Sea Link Energy Cable

**Appendix E3a to the Natural England Deadline 3a Submission
Natural England's Intertidal and Benthic Ecology Advice**

Planning Inspectorate Reference EN020026

19th January 2026

**Figure 1. Landfall Concept Drawing (see page below)**

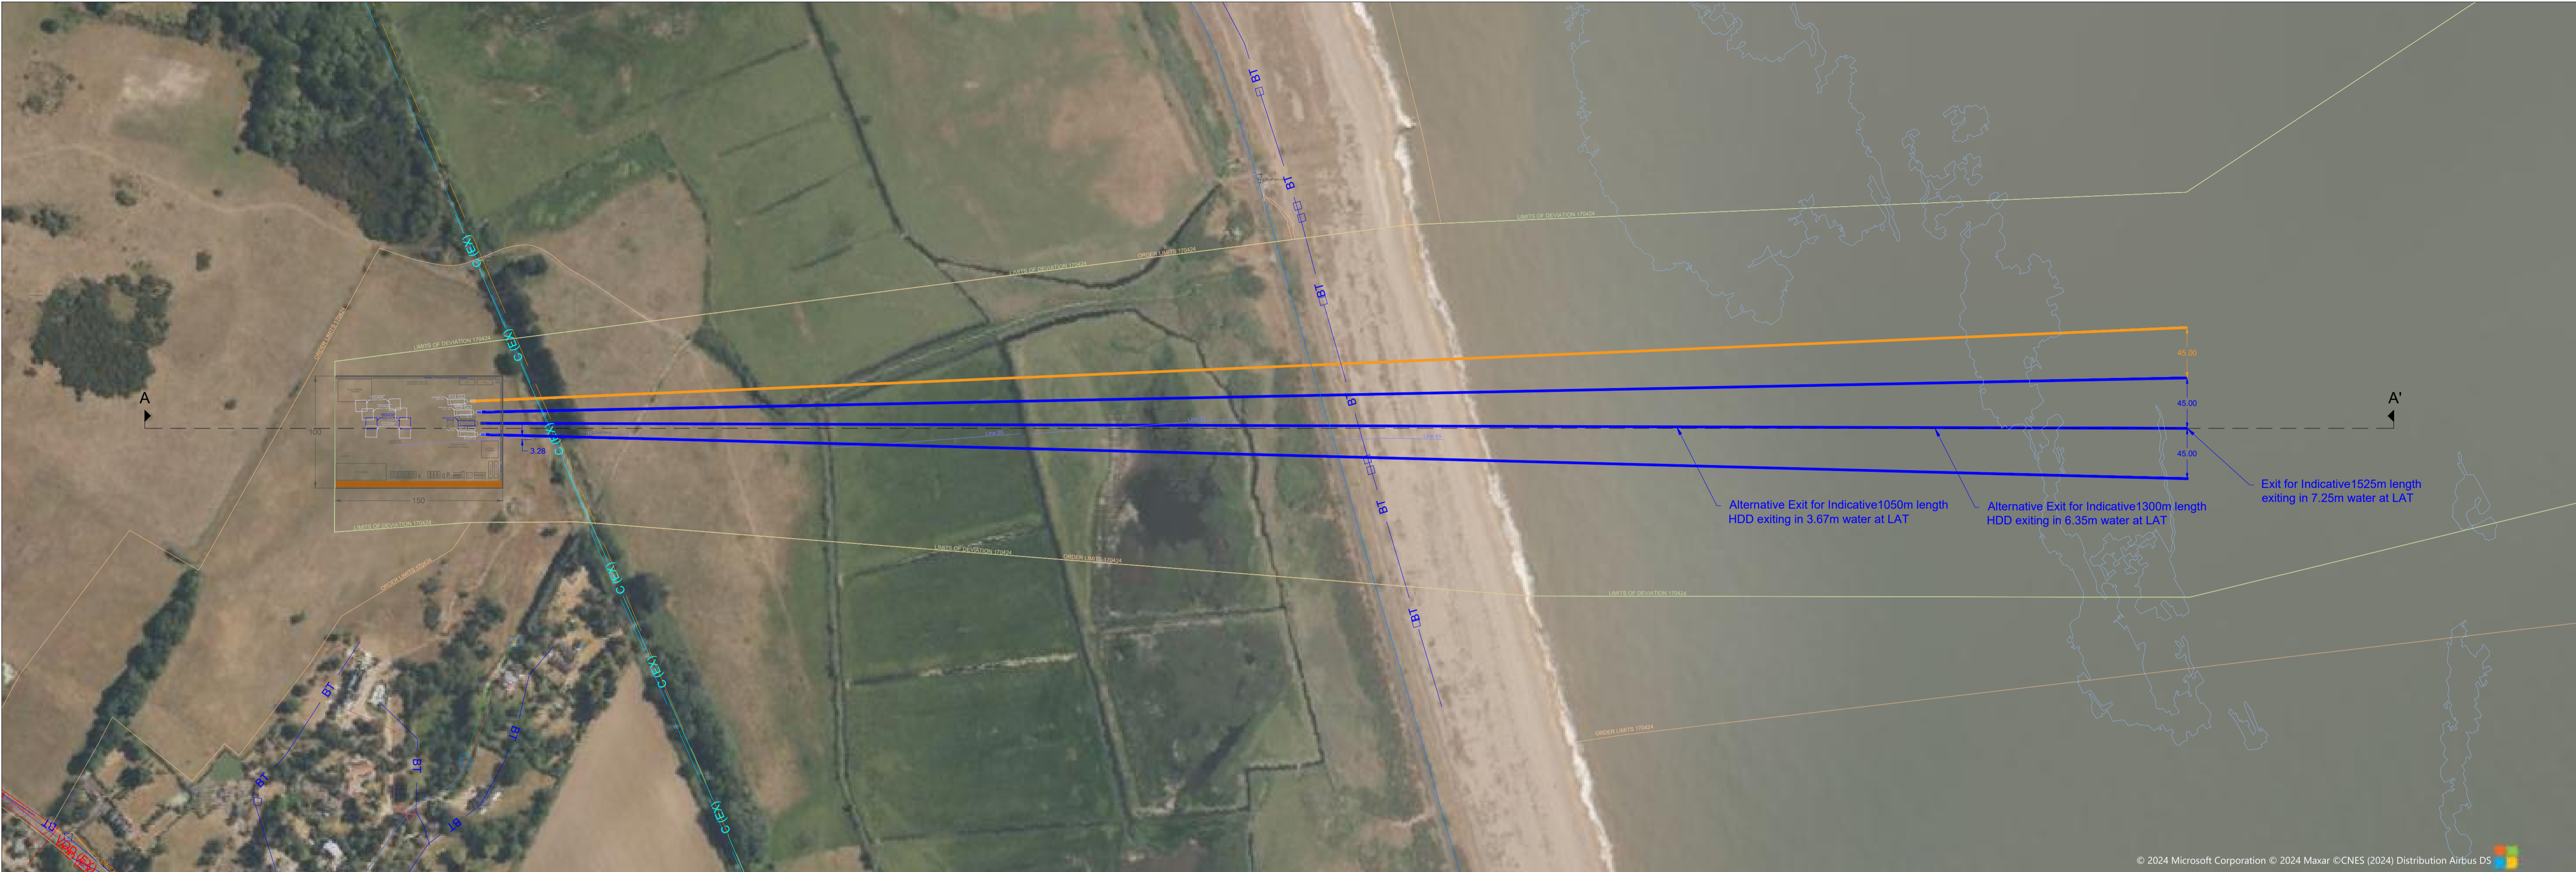
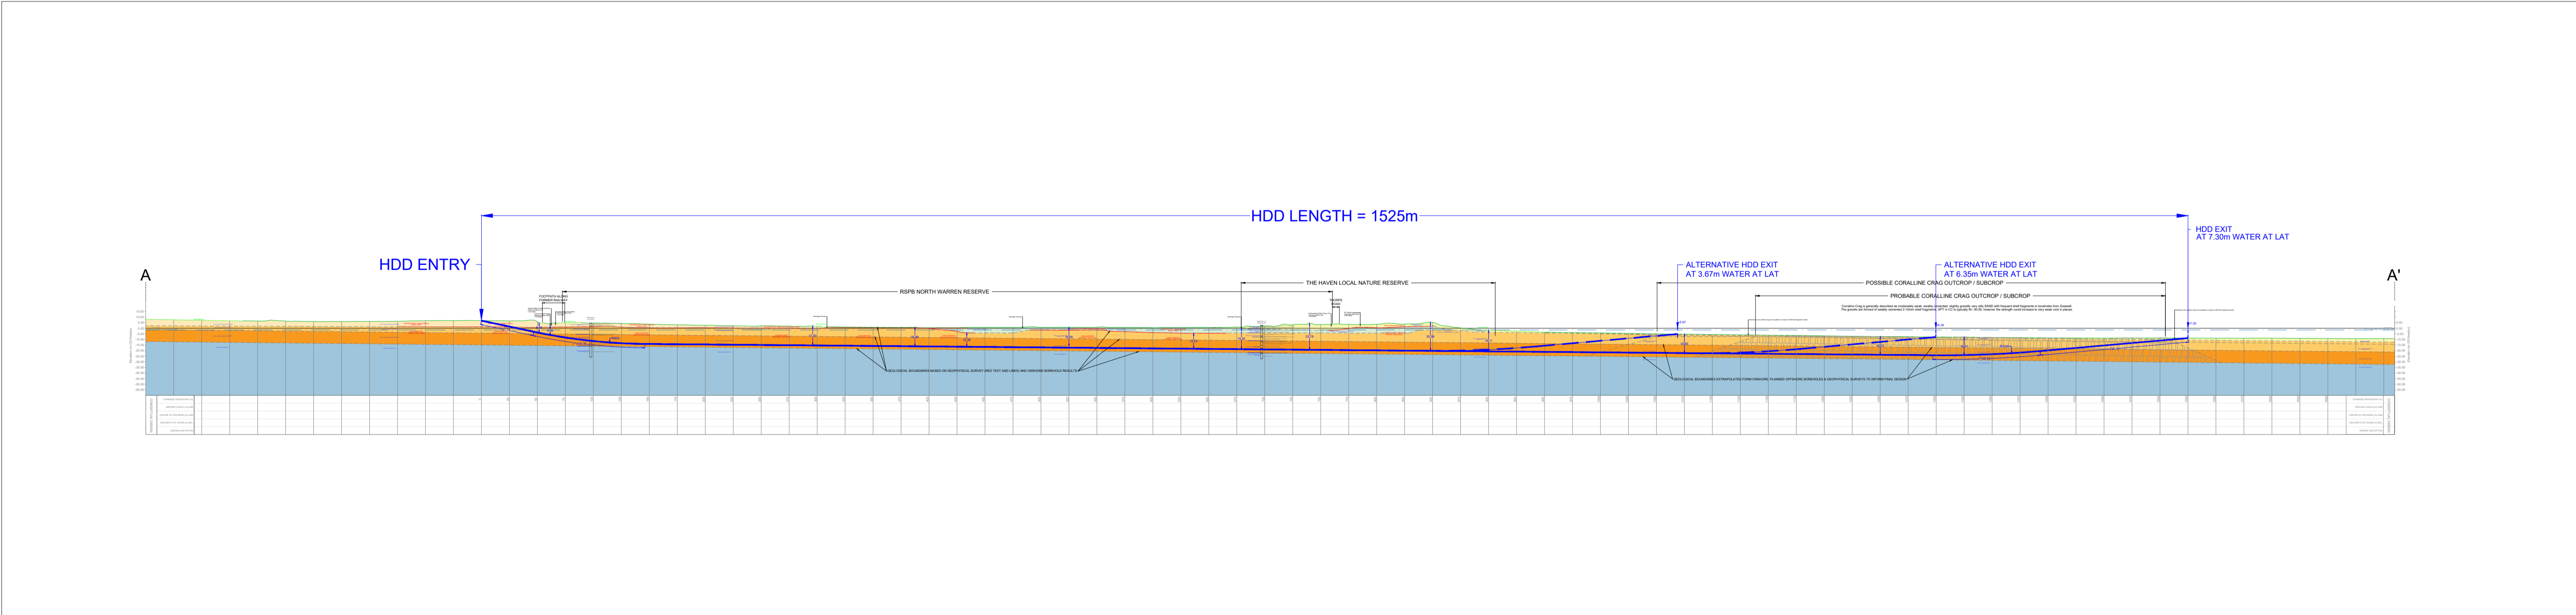
Document reviewed: [PDA-037] 9.20.1 Landfall Sediment Modelling Report Aldeburgh			
NE Ref	Section	Key Concern and/or Update	Natural England's Advice to Resolve Issue
3	Figure 1, and Sections 1.2 & 3.5.2	Further to our Relevant Representation advice [RR-3290], we note that all three HDD exit options appear to be located in areas where Coralline Crag is present yet there is no assessment of potential impacts on the Coralline Crag due to the HDD or cable installation at landfall.	Natural England advises that potential scale of the impacts to the crag needs to be clarified. We also advise that potential impacts on the Coralline Crag due to cable installation and HDD need to be fully assessed and evaluated. Furthermore, we advise that impacts to the

<p>We draw the ExA's attention to previous energy projects including Sizewell C and East Anglia 1N and East Anglia 2 which have all designed their projects to avoid impacts to this unique irreplaceable geological feature only found in the area around Aldeburgh and Orford.</p> <p>In [AS-114] it is stated that the HDD exit point will target an exit location that will be designed such that there is not a risk of exiting where the Coralline Crag is at the surface. It is also stated that during detailed design, the HDD contractor will microsite the exit points based on seafloor surveys and ground investigations. However, in [PDA-037] it is stated that all 3 potential points will go through the crag, and it is not stated whether drilling through this geological feature may have any impacts on the crag.</p>	<p>Coralline Crag should be avoided and/or minimised when selecting the marine exit site and onwards with cable installation works. And where installation impacts can't be avoided to the crag we advise that there is a further assessment of placement of cable protection in this location due to potential scouring of the feature and disruption to sediment transport.</p>
